Town of Addison
Summary of Engineering Revision Comments

Development: Galaxy FBO

Town Project #:19-09D

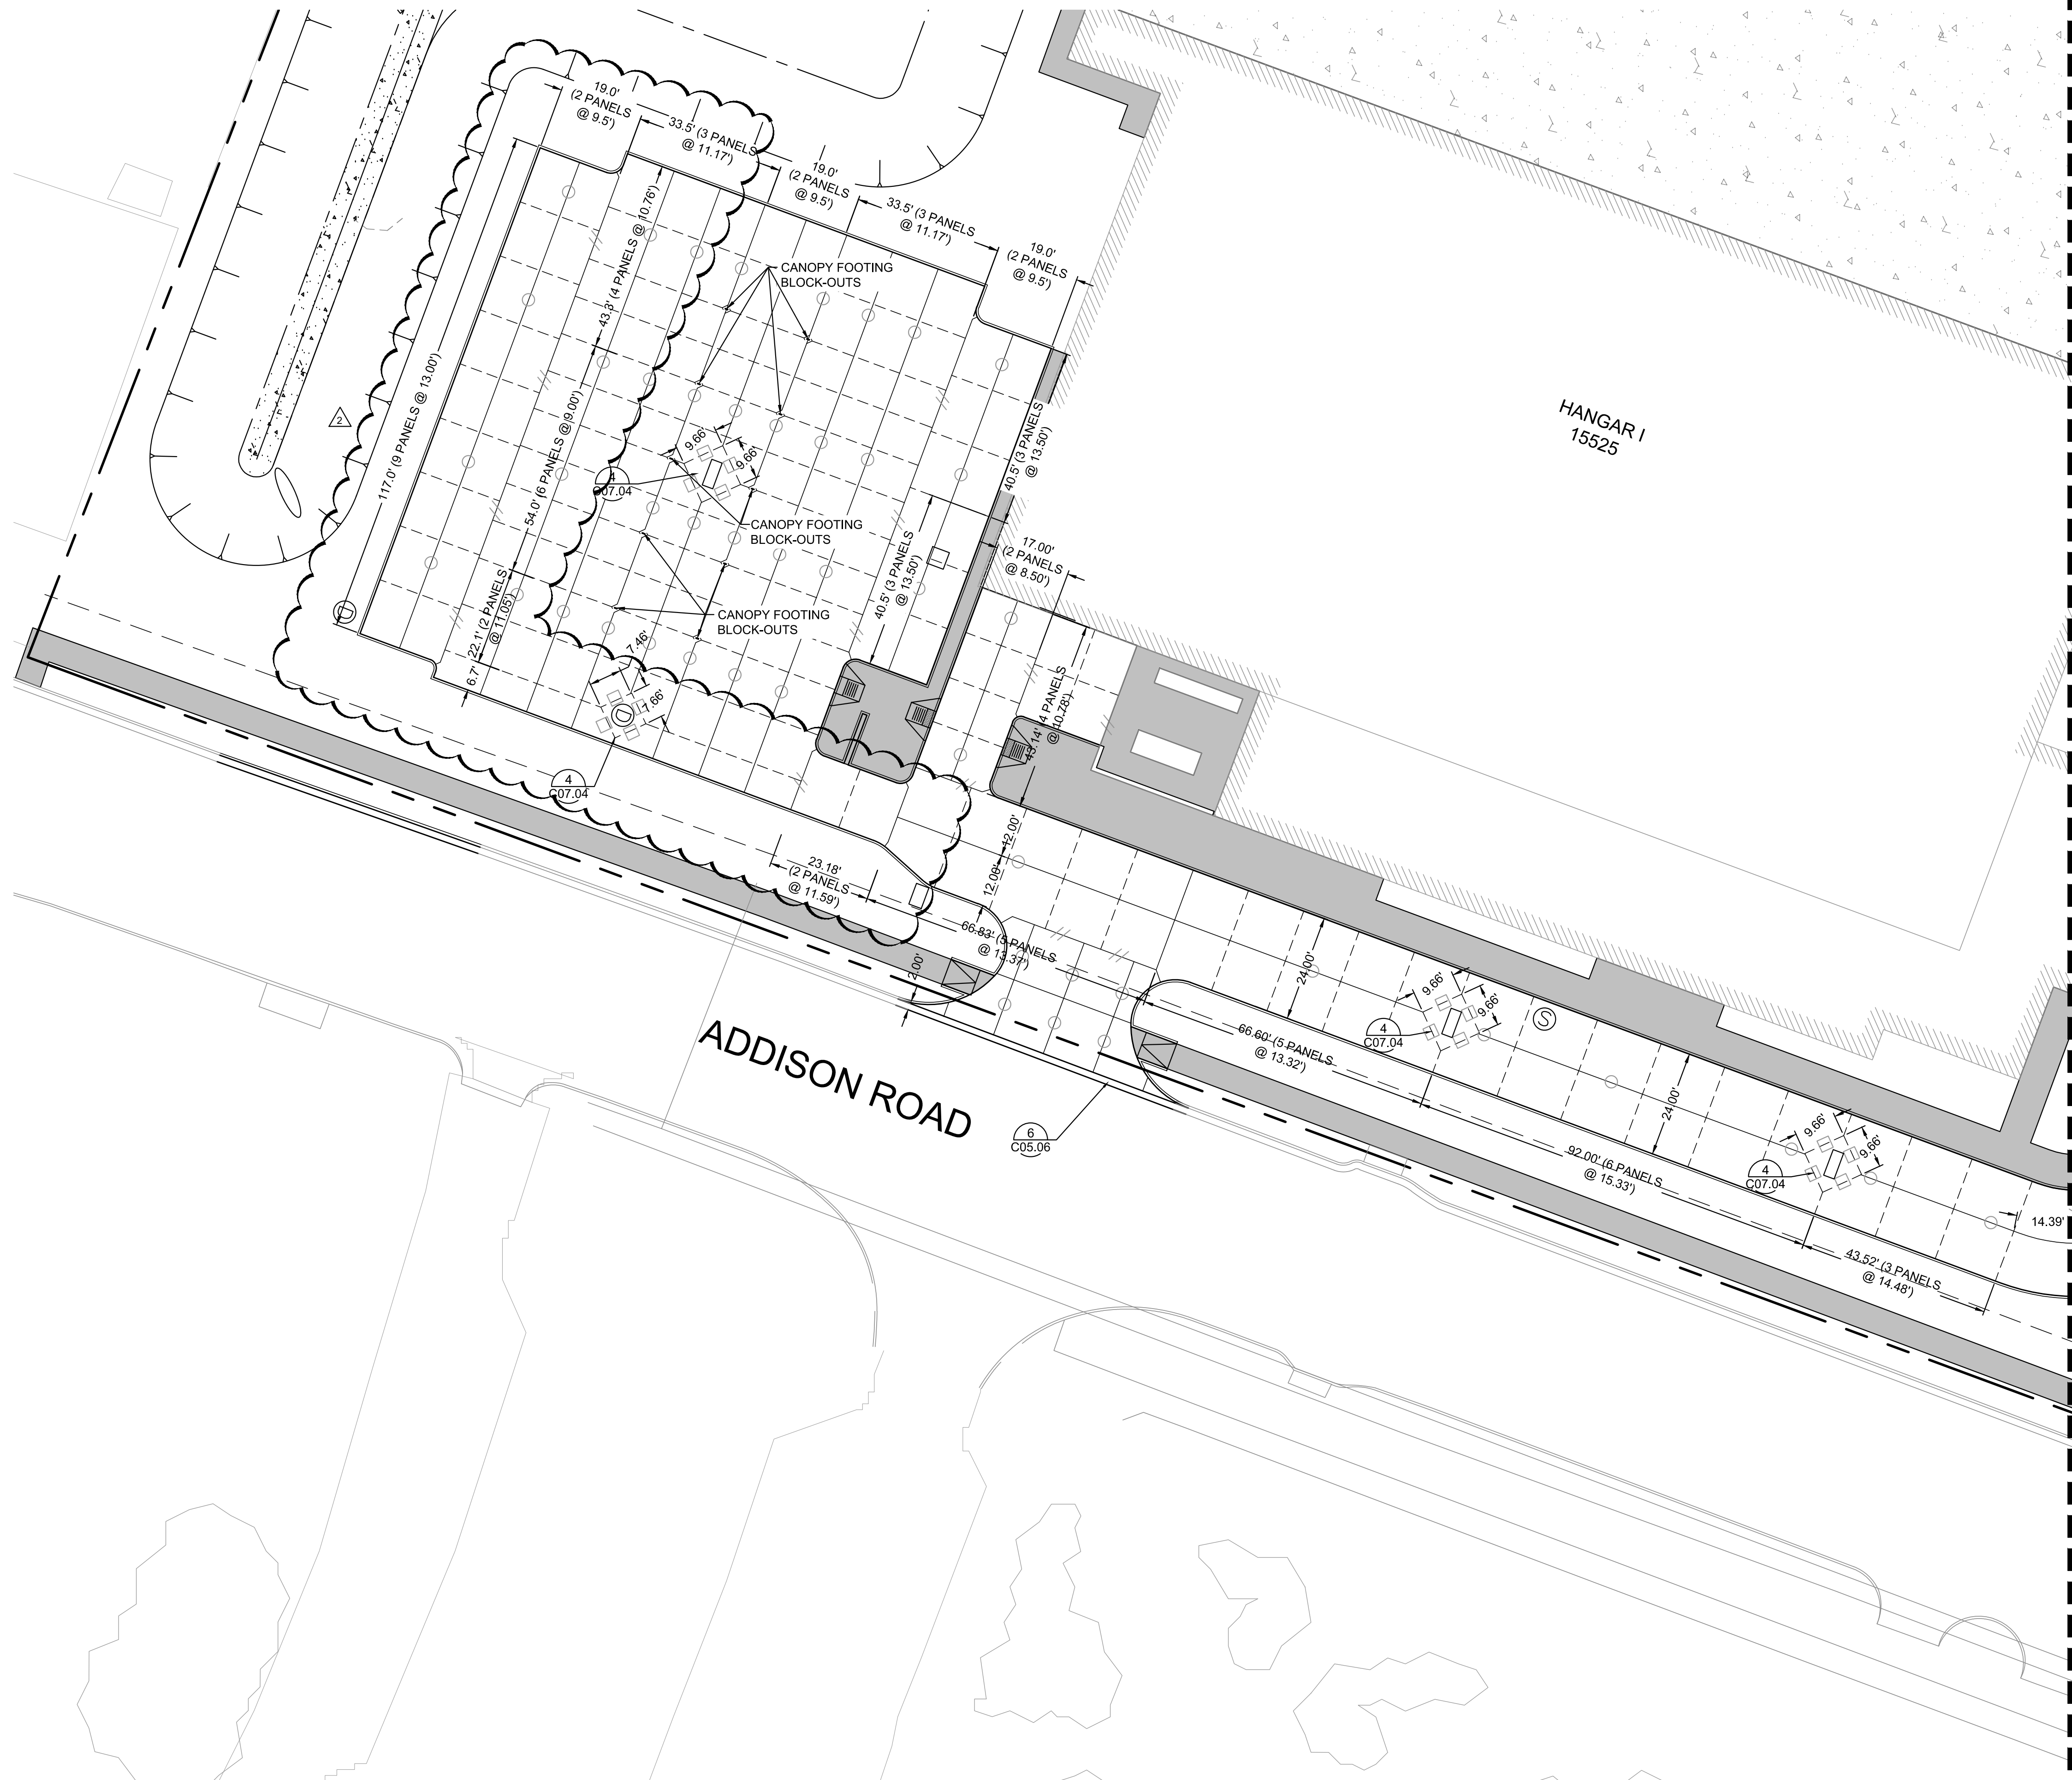
ASI-C005	8/7/2020	C05.02	Added the public art plaza area.	
ASI-C005	8/7/2020	C05.04	Adjusted point number 11, 19, 20, 21, 22, 23, and 24. Also added point 280 - 298	
ASI-C005	8/7/2020	C07.01	Adjusted joint spacing based on the modification to the east curb line of the parking area at the south end of the site.	
ASI-C005	8/7/2020	C09.01	Adjusted elevations based on the modification to the east curb line of the parking area at the south end of the site.	
ASI-C005	8/7/2020	C09.02	Added elevations on the sidewalk and ramps that were added/adjusted around the public art plaza.	
ASI-C005	8/7/2020	C10.05	Adjusted elevations based on the modification to the east curb line of the parking area at the south end of the site.	
ASI-C005	8/7/2020	C10.06	Adjusted elevations on the sidewalk and ramps that were added/adjusted around the public art plaza.	
ASI-C005	8/7/2020	C16.04	Removed one parking stall for the parking area at the south end of the site.

ADDISON GALAXY FBO
 15601 ADDISON RD.
 PREPARED FOR
 BLACK FOREST VENTURE
 DALLAS, TEXAS
 ADDISON
 SHEET NUMBER
C17.01

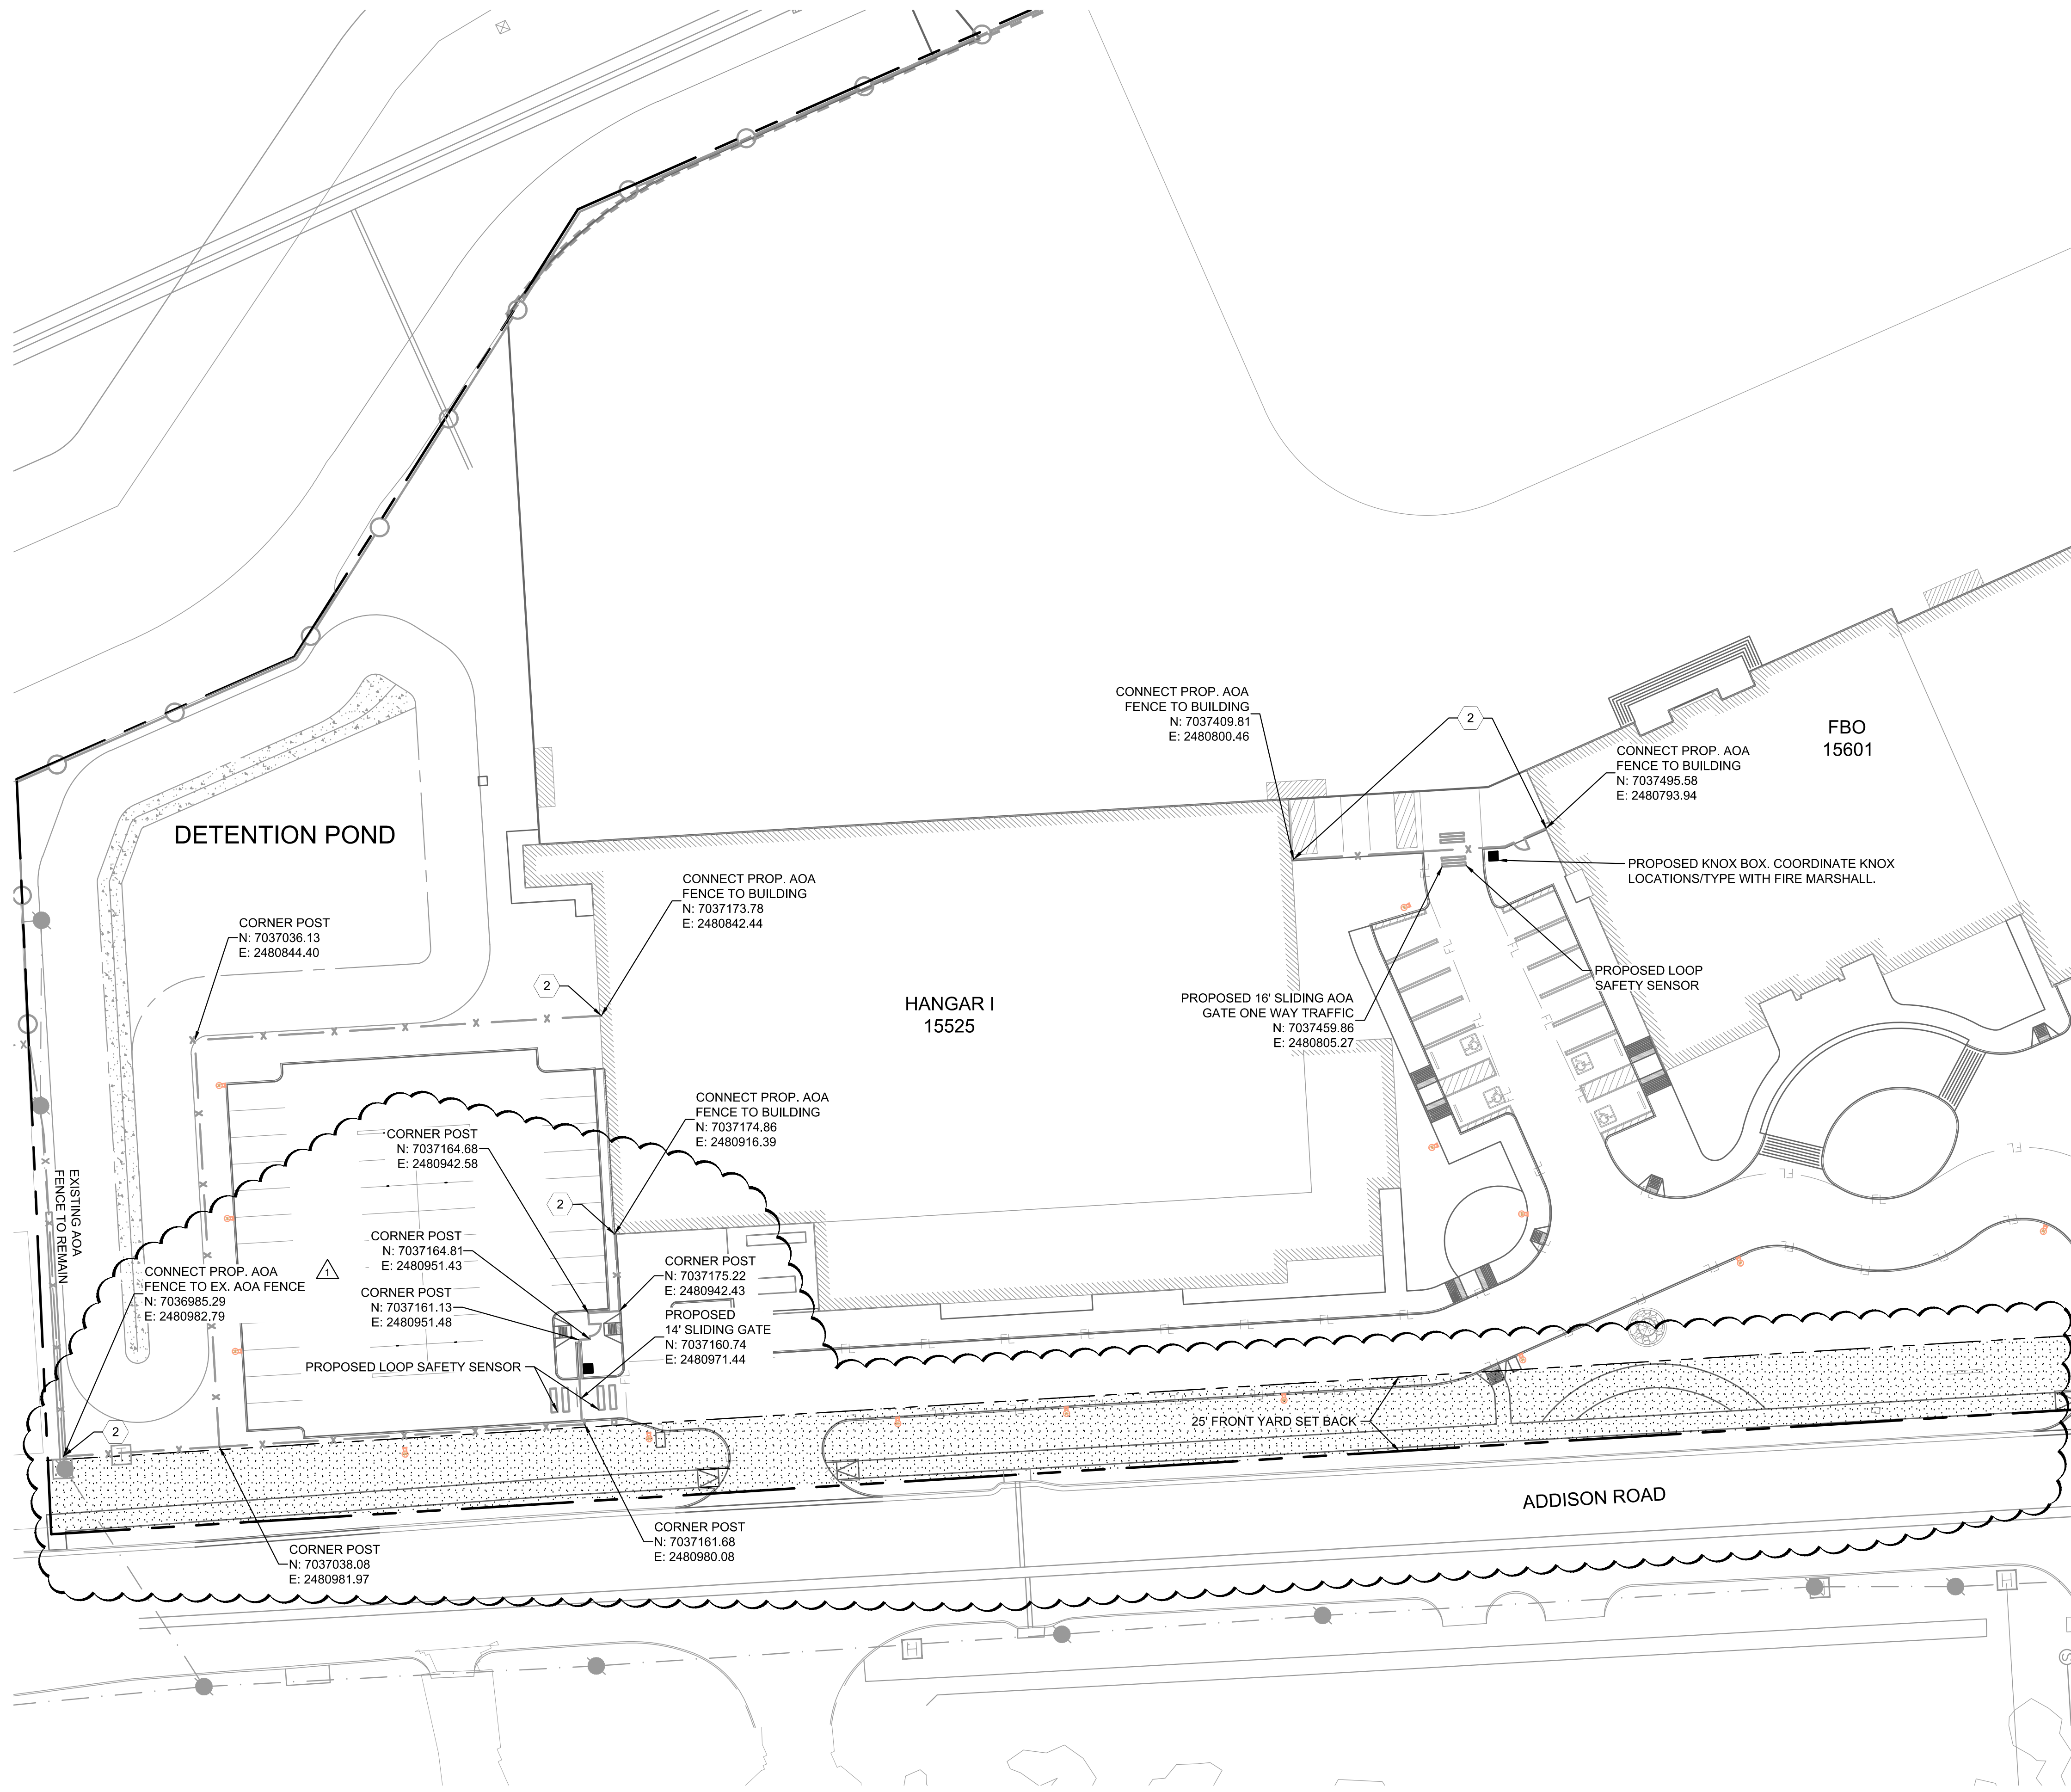
ASI-C005	8/7/2020	C17.01	Moved the chain link fence on the east side of the parking area on the south end of the site so it is outside the 25-foot front yard setback, and removed the ornamental fence and gate previously proposed along Addison Road.	
ASI-C005	8/7/2020	C17.02	Removed the ornamental fence previously proposed along Addison Road.
